24/07/2020

**Maxwell Underground Coal Mine Project (SSD-9526)
Request for Additional Information**

Attachment A

Enclosure 4
Existing and Proposed Biodiversity Offset Areas

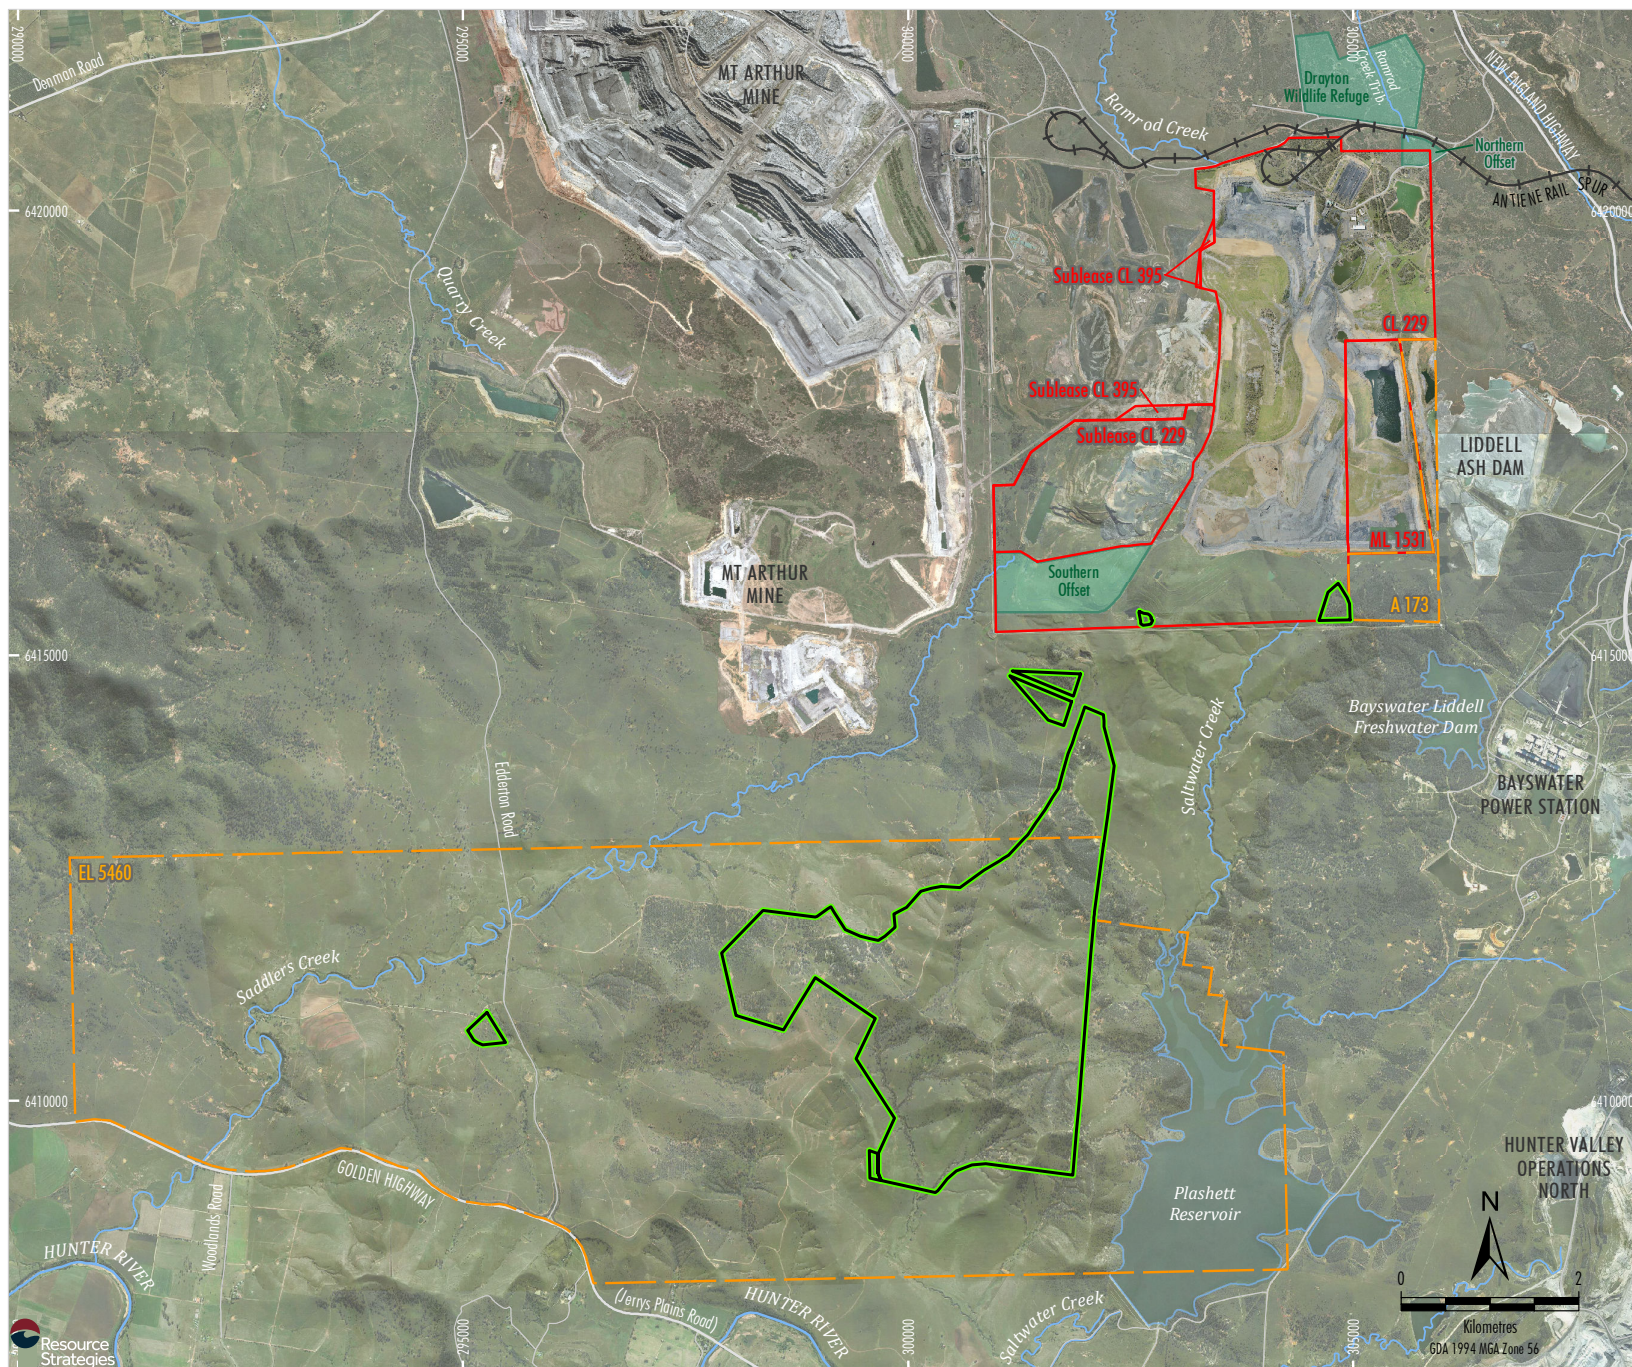
5. The Department requests a single figure showing the location of the Drayton Wildlife Refuge, Northern Offset Area and Southern Offset Area and the potential offset area for the Project.
